DRB Application No.: **03-02000 (SBP)**
Project Name: **ALAMEDA BUSINESS PARK**
Agent: **G. Donald Dudley Architects**

**CITY OF ALBUQUERQUE
PLANNING DEPARTMENT
Development Review Board
12/3/03 Comments**

RE: LOT 9, ALAMEDA BUSINESS PARK/ SDPBP

1 NORTH ELEVATION  
SCALE: 1/8"=1'-0"

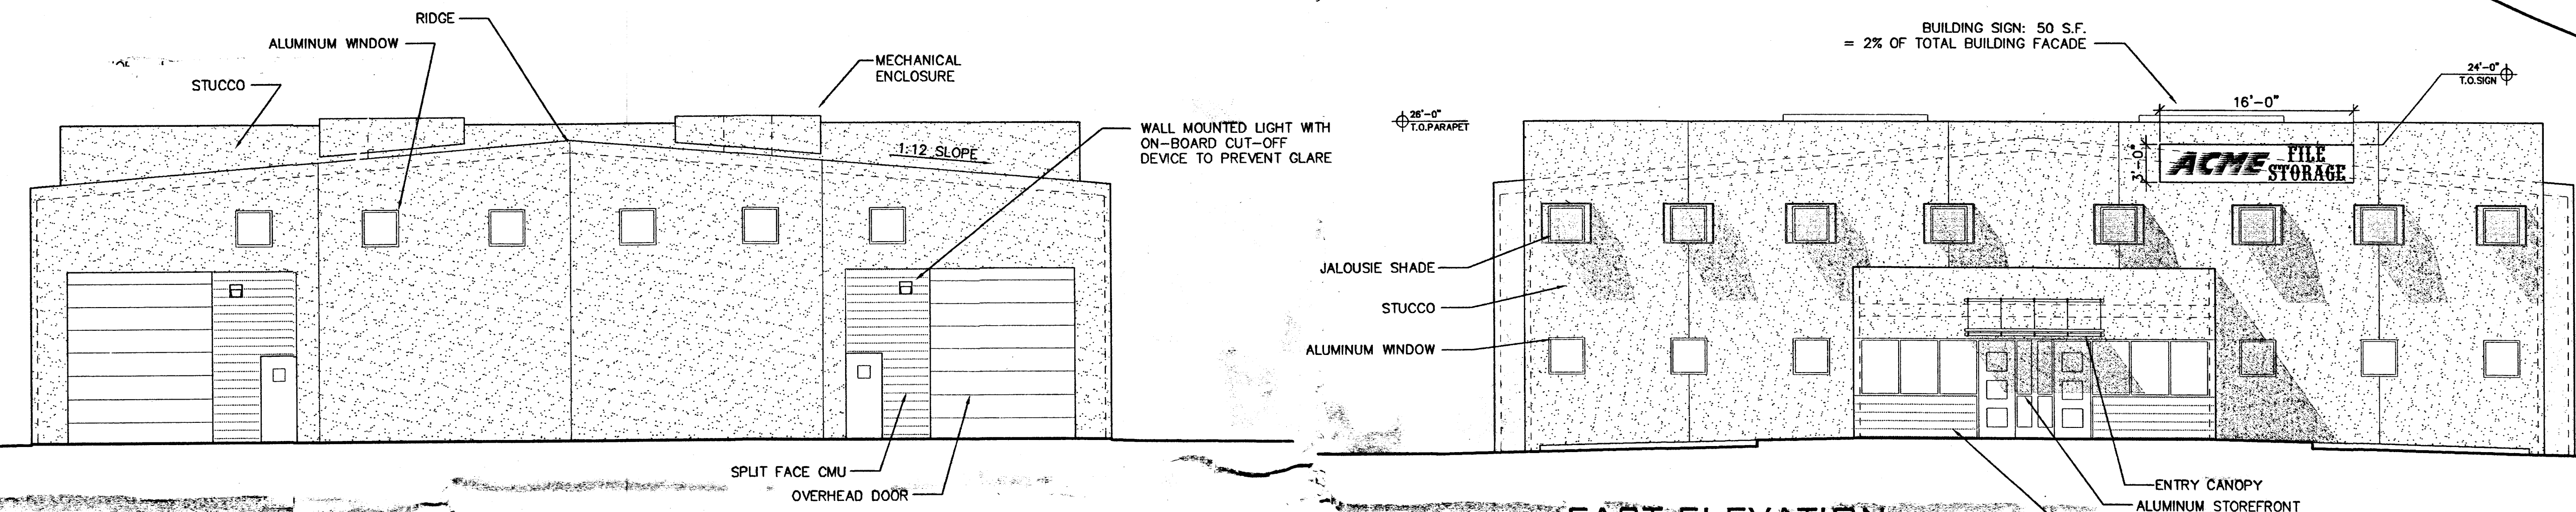
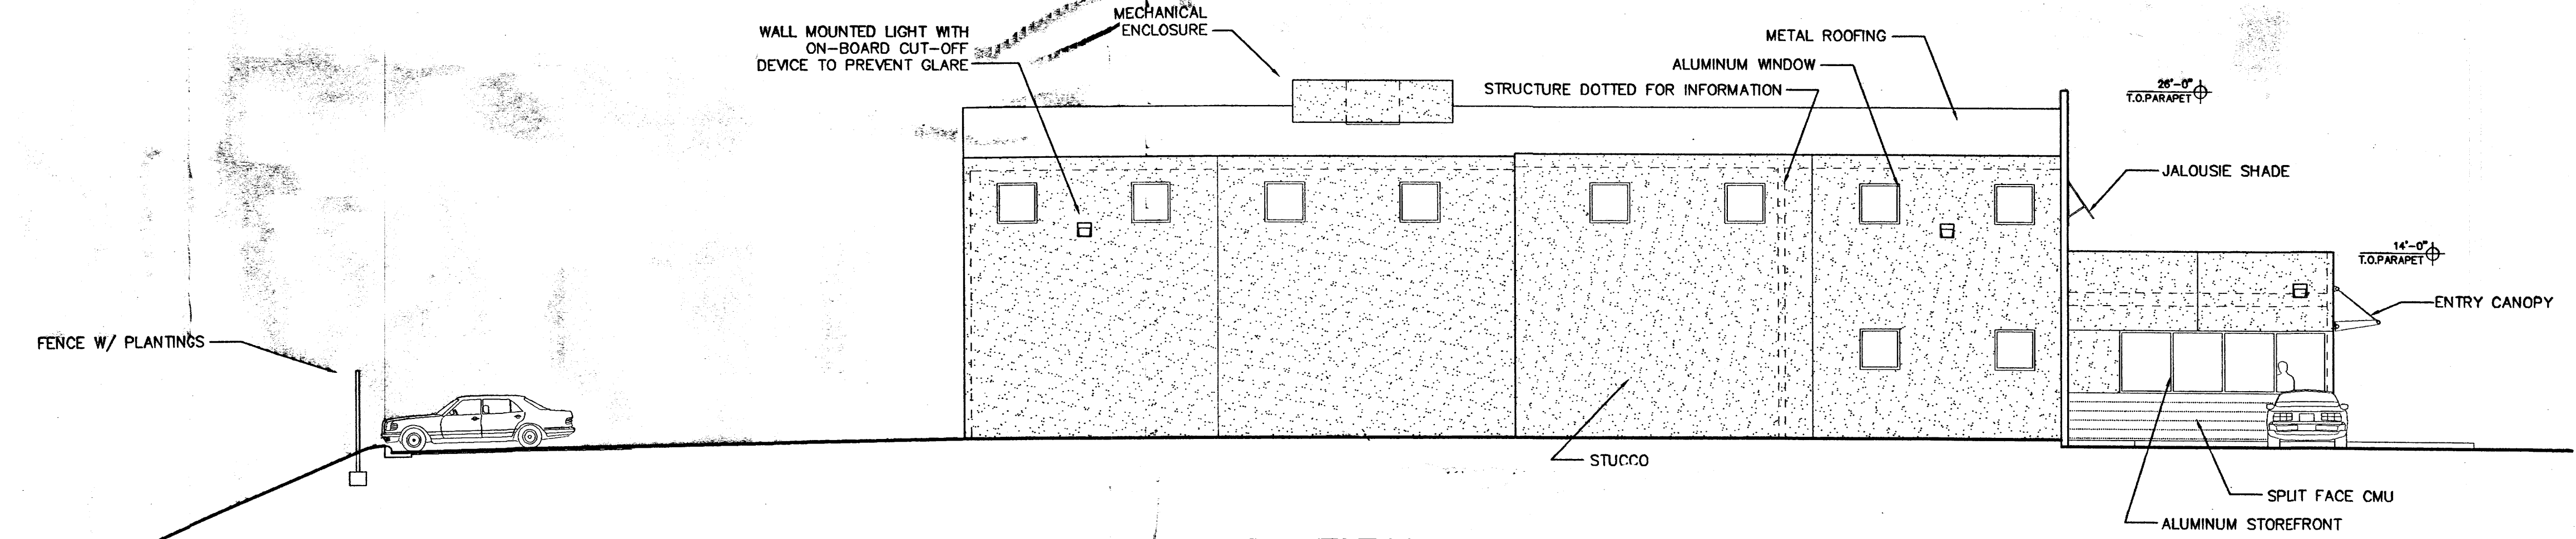
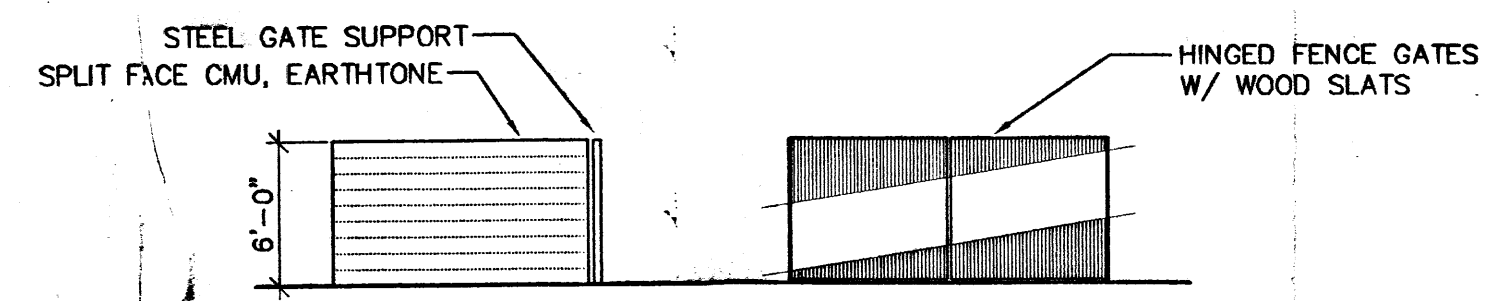
6. Are there any off site structures within 20 feet of this property? If so, they should be shown on C1.1.
7. An elevation drawing of the refuse container & enclosure with dimensions, colors & building materials should be included on the building elevations sheet.

- All metal building surfaces are to be earth tones. Other colors are limited to 10%.
- Will the rear of the building be visible from Edith? If so, no metal siding is allowed.
- The colors of the major facades should be muted or pastel tones.
- The mechanical equipment on the roof must be screened from public view. Please state this on the building elevations sheet.
- Specify the colors to be used on the building elevations sheet.
